Reference No:	<b>2026/62/91201/E</b>
Site Address:	Knowle Newsagents, 1, The Knowl, Mirfield, WF14 9RH
Description:	Change of use of first and second floors from storage to 2 No. 1 bedroom self-contained residential flats (Use Class C3), erection of rear dormer extension, and removal of chimney
Recommending Officer:	Elenya Jackson

**DECISION – REFUSED**

## **Officer Report**

PROPOSED SECOND FLOOR PLAN
SCALE 1:100

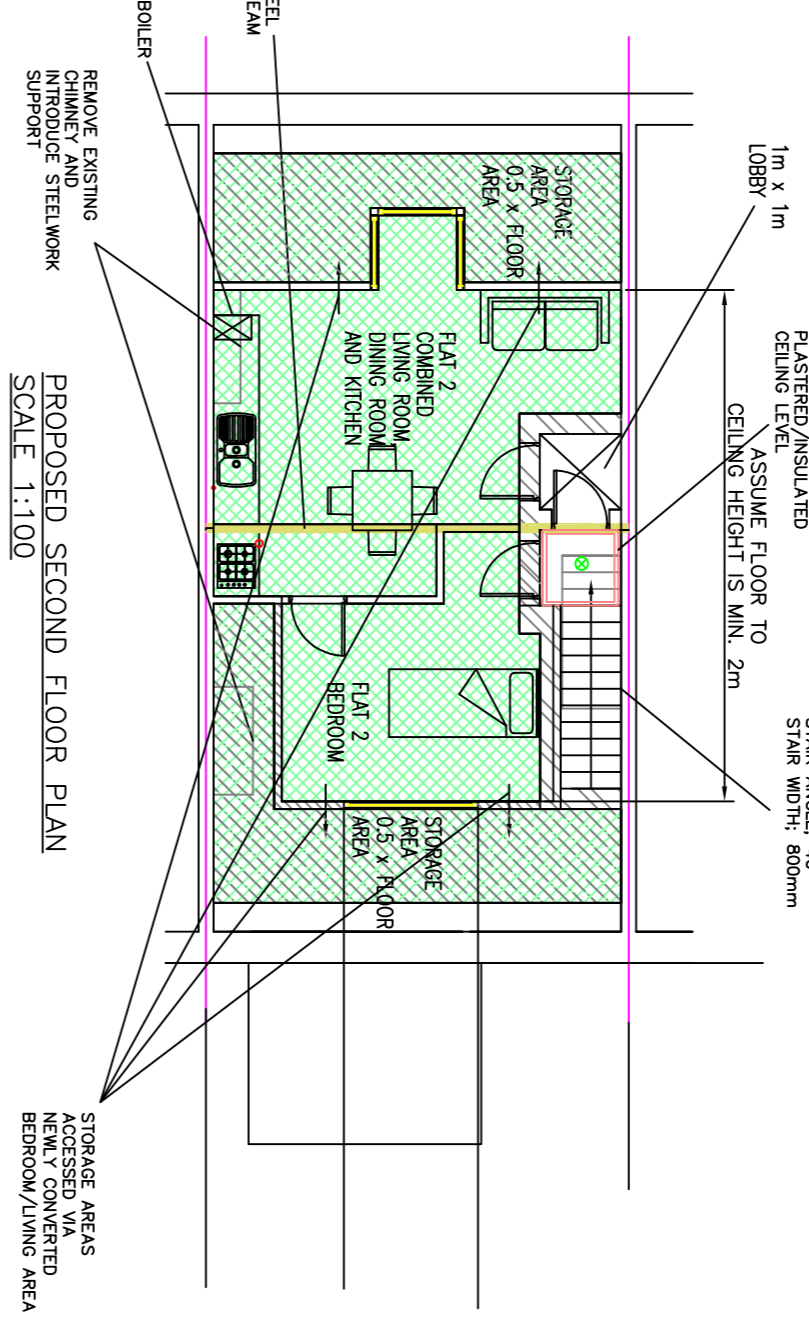
When measuring flat two, officers consider that the main bedroom and kitchen have a floor space of 28m<sup>2</sup>, when measuring the whole floor area on the second floor, this would measure 53m<sup>2</sup>; however, this would be by the eaves and in accordance with part g of the technical requirements 'any other area that is used solely for storage and has a headroom of 900-1500mm (such as under eaves) is counted at 50% of its floor area, and any area lower than 900mm is not counted at all.

Therefore, these areas are to be counted as half their footprint. This would result in the area next to the bedroom of the second flat having a floor space of 4.5m<sup>2</sup> and the area adjacent to the living area having a floor space of 4m<sup>2</sup>. Therefore, the second floor of the flat would have an area of 36.5m<sup>2</sup>.

However, the bathroom of the proposal does not fit within the second floor of the building and is located next to flat one's bedroom. This would have an area of 4.2m<sup>2</sup>.

As a result, this dwelling would be located over two storeys and is therefore required to have an internal floor space of 58m<sup>2</sup>.

The proposal would fall substantially short of this requirement having an internal floor space of 40.5m<sup>2</sup> for a one bedroom dwelling over two storeys.

Coupled with the layout of the proposal which would see accommodation for flat 2 predominantly within a roof area, it is considered flat 2 has a contrived layout which requires an area of floor space on floor 1 to provide the amenities required within the flat.

The extent of floor space provided, coupled with the layout of the flat leads to the conclusion that flat 2 as detailed within submitted drawing S02revF fails to demonstrate an acceptable standard of living for the future occupier of flat two.

1. The accommodation demonstrated in relation to flat 2 upon the submitted drawing titled 'Proposed Plans and Elevations' ref: S02revF would fail to accord with the nationally described space standards and would fail to adequately meet basic lifestyle needs. Therefore, the proposal would provide an unacceptable standard of living accommodation for future occupants and would fail to accord with Policy LP15(d), LP24(b) of the Kirklees Local Plan, Principle 16 of the Council's Housebuilders Design Guide SPD, and Paragraph 135(f) of the National Planning Policy Framework

PROPOSED CROSS-SECTION THROUGH ROOF/REAR DORMER
SCALE 1:100

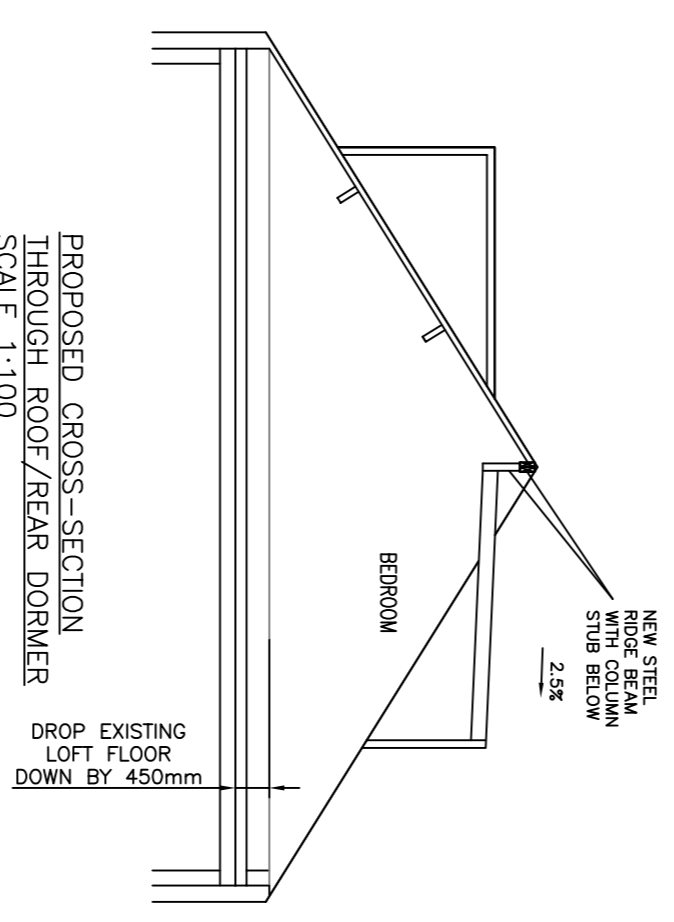
The submitted plans demonstrate that alterations would be required the building to facilitate the change of use including the erection of a rear dormer. This would have a flat roof with a width of 3.8m and a height of 1.8m

It is considered that the proposed dormer would be set down from the ridge of the property and above the eaves which would allow it to integrate with the roof space of the existing building. It would have limited views from the wider area.

The dormer is proposed to be finished in grey shiplap cladding which as the dormer on the front of the property is constructed out of wood, would be acceptable in this case. An appropriately worded condition to ensure satisfactory completion of the dormer in suitable materials of construction would be included upon any grant of permission.
